Northconnex EIS Submission – Traffic and Transport - SSI 13_6136

Northconnex EIS Submission – Traffic and Transport

Figure 11: 2019 and 2029 AWDT along M1-M2 corridor without and with NorthConnex tunnel

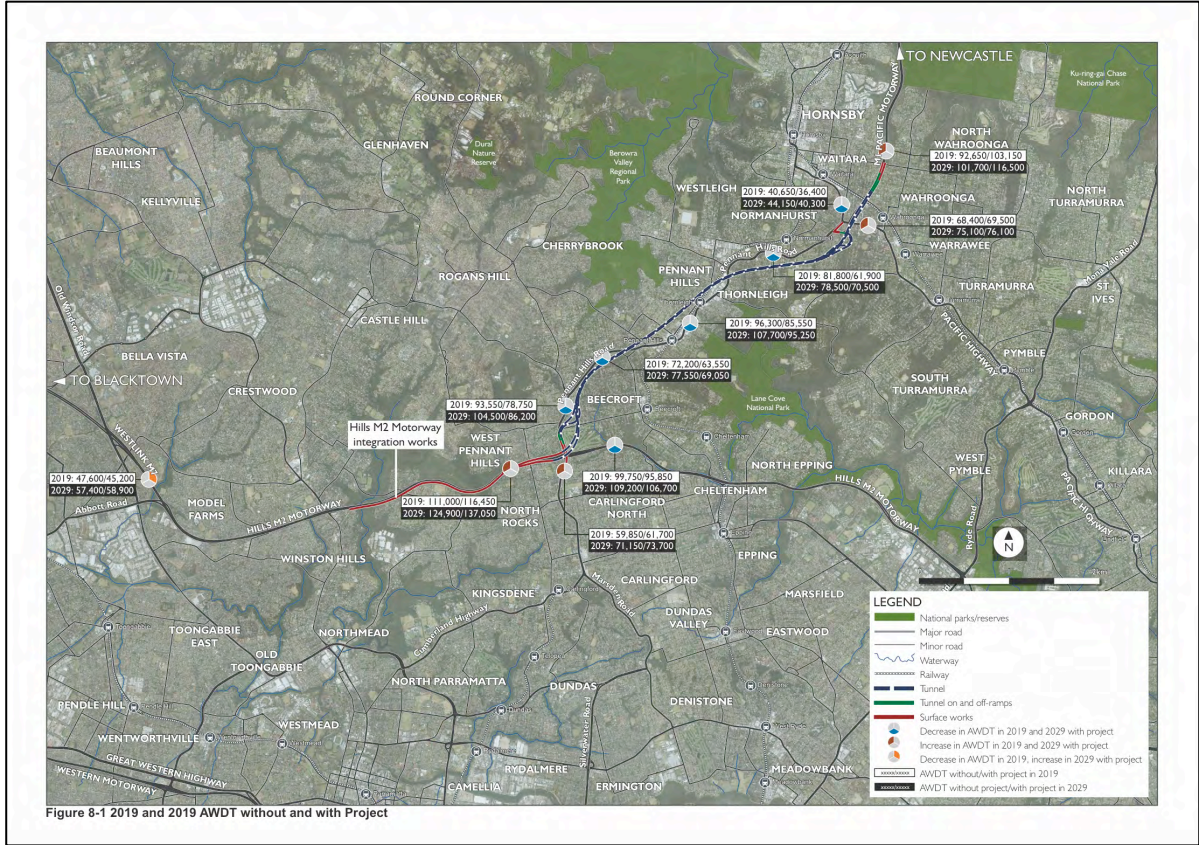
- the 7 key mid-blocks ‘with’ and ‘without’ traffic predictions (Strategic Transport Model)
 - total vehicles per day
 - northbound and southbound detail
 - the Comenarra Parkway to Pacific Highway mid-block numbers differ significant from Figure 8.1 – see Section 8. Operational Traffic Impact Assessment following.
- **what explains the above Figure 8.1 variance?**

Figure 8.1 is referenced twice above and deserves special attention

5. Reference above **Table item A**. what explains the 10500 vehicle increase in 2019 on the M1 (F3)? – *The EIS states - minimum changes in future traffic volumes is expected on the M1 (F3) as a result of the project. So why the 'immediate' 11.3% increase?*

6. Refer above **Table item B**. what explains the 4250 vehicle decrease in 2019 on the Pacific Highway north of Pearce's Corner? - *If this Pacific Hwy traffic is forecast to opt for the F3 is this a two way phenomena? and where would the switch be made?*

7. Refer above **Table item C**. what explains the 'with' number being a marginal increase over the 'without' number in both 2019 and 2029? - *If this is related to Pacific Highway traffic being attracted into the tunnel see Question 18 below?*

8. Refer above **Table item D**. which is correct, the above 'with' and 'without' numbers for both 2019 and 2029 or the equivalent numbers in Table 6.2 and 8.4? And, what flow on effect does the correction of this anomaly have?

10. Refer above **Table item E**. – the reduction of traffic on this segment of Pennant Hills Road (19900) is the simplest indicator of tunnel traffic. *So what explains the difference with the 29955 in EIS Table 8.5?*

11. Refer above **Table item F**. what explains the 'without' number for 2029 being less than the 2019 number?
12. Refer above Table - the 'Comenarra Pkwy to Beecroft Road' segment shows 'without' traffic in 2019 at 96300 and 'with' traffic in 2029 at 95250. *These numbers support the EIS conclusion that background growth the spare capacity provided by the tunnel!*

14. Refer above **Table item H.** what explains the increase in 2019 and 2029 'with' numbers over the 'without' numbers when the only thing that has changed is the opening of the 'alternate route' tunnel?

15. Refer above **Table item I.** what explains the decrease in 2019 and 2029 'with' numbers below the 'without' numbers when nothing has changed with regard to M2 (East) traffic?

16. Refer above **Table item J.** what explains the increase in traffic numbers as a result of the tunnel? *It should be noted that the Pennant Hills Road (south) traffic growth forecast 2019 to 2029 at 118.9 % 'without' and 119.4% 'with' is greater than any other road segment including the M2.*
